ENG-CDR21010-R3-CDs-Vollmer-North.pdf Markup Summary

SIGNAGE & STRIPING

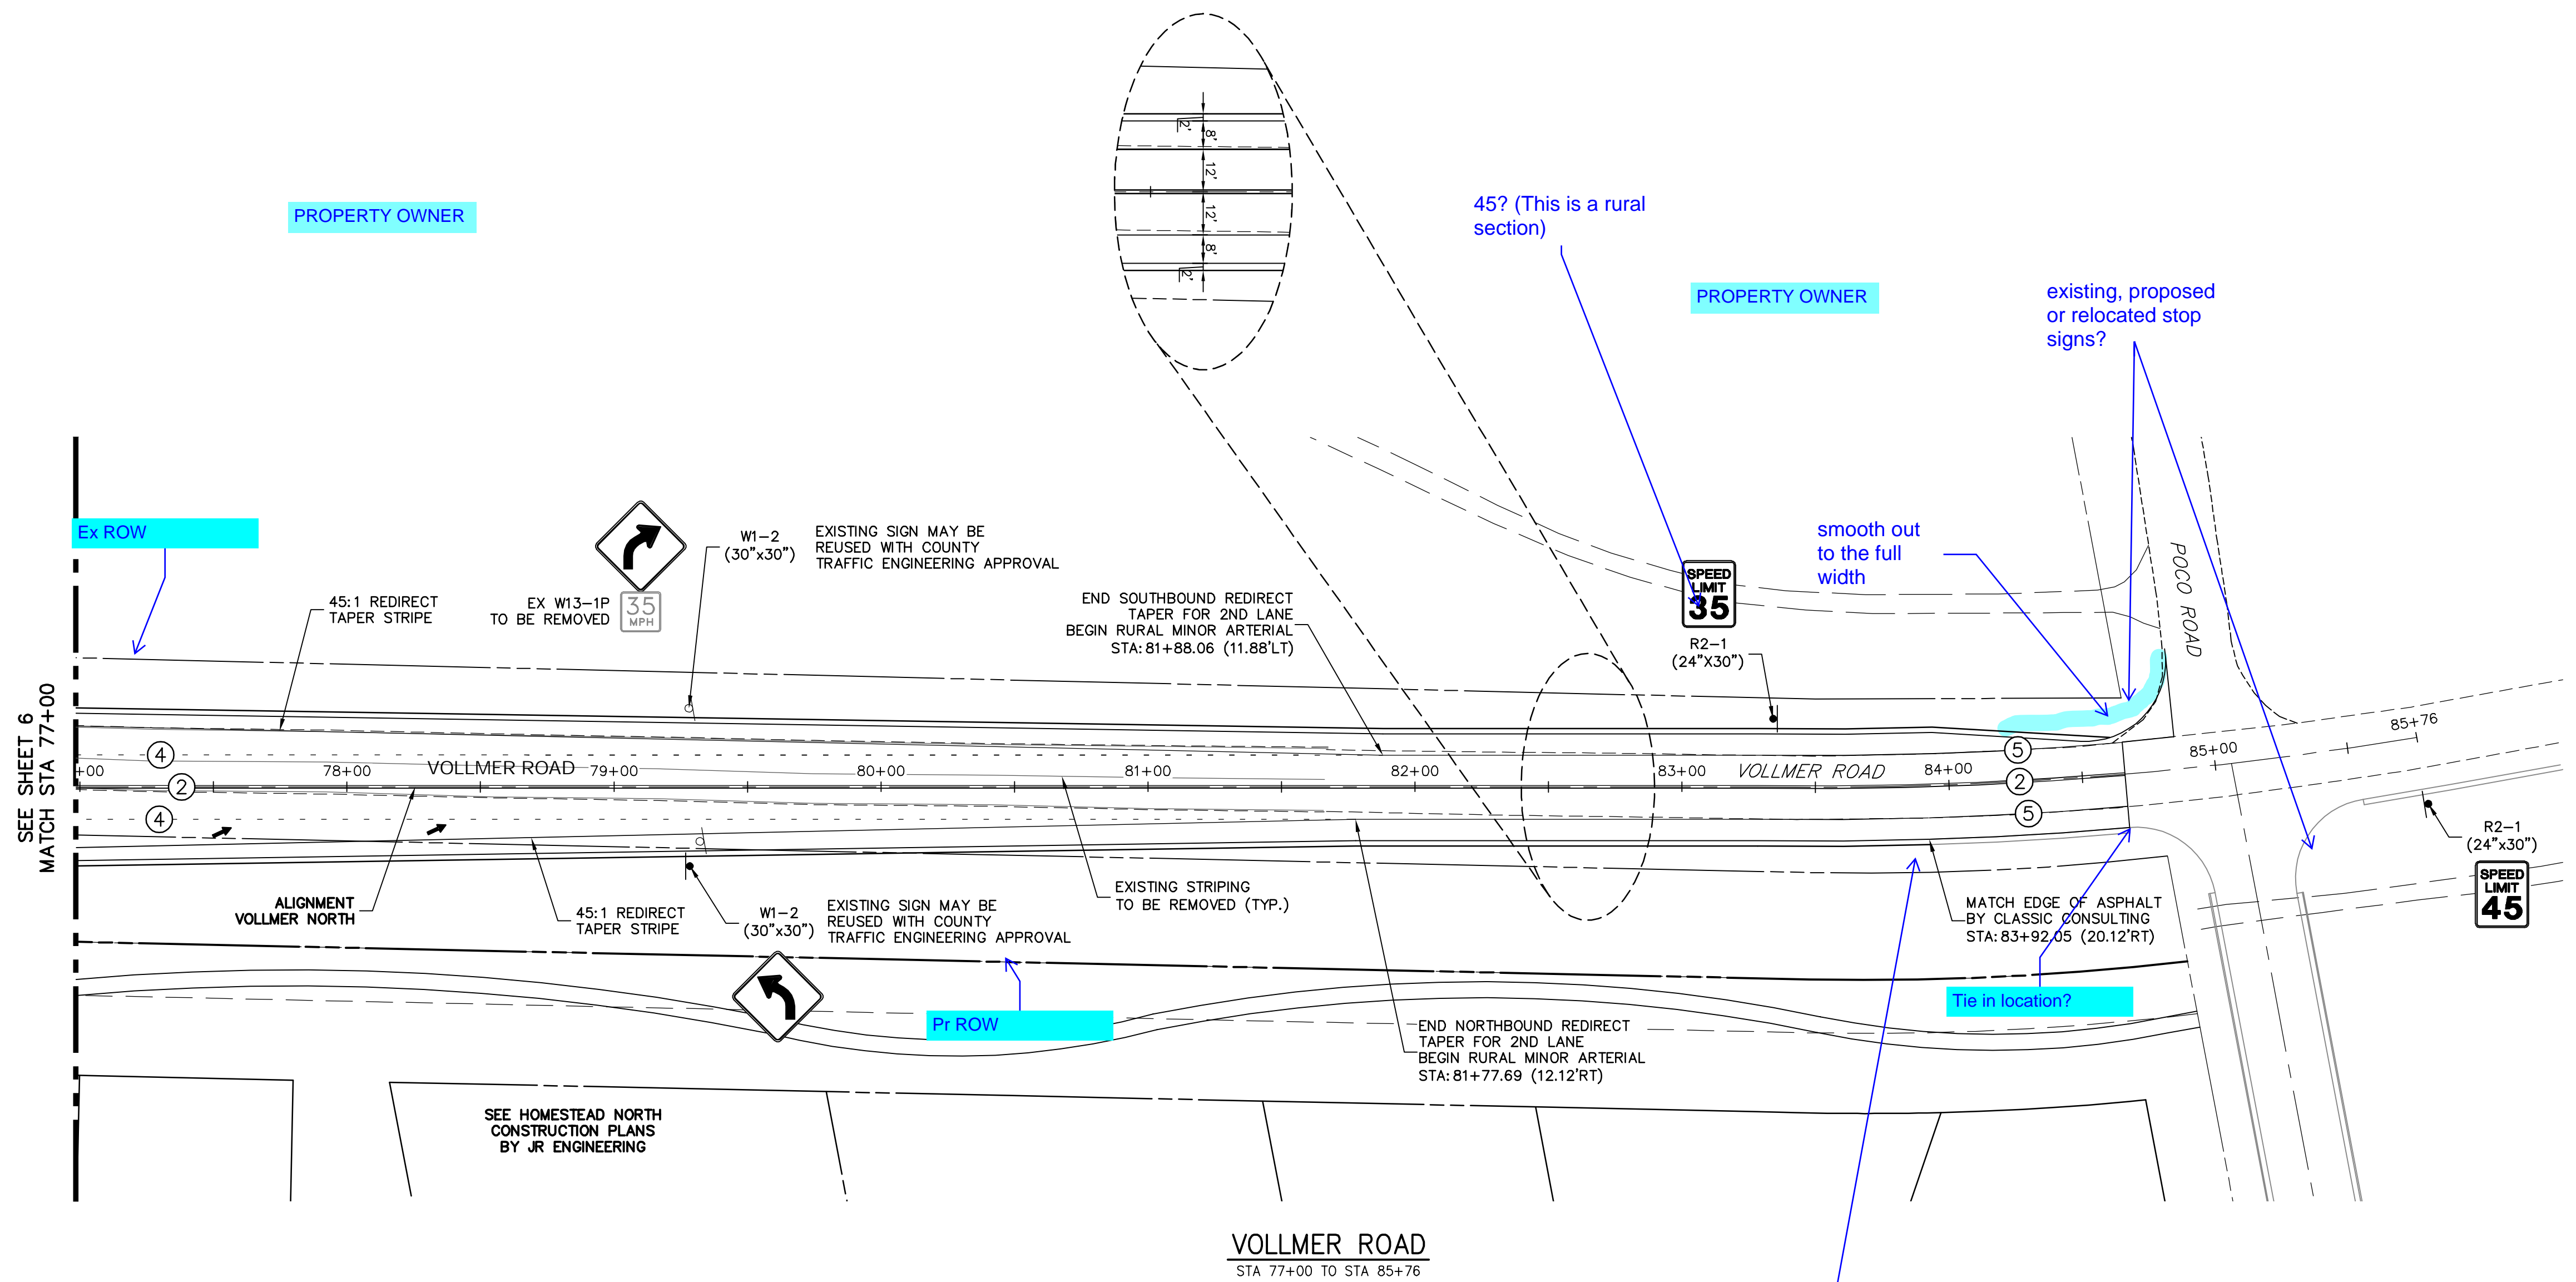
Per comment on previous sheet, if posted speed prior to Poco is 55 mph, then will need to be a 45 mph sign.

When is NB right turn lane being added? Retreat at Timber Ridge Filing 2 calls for it.
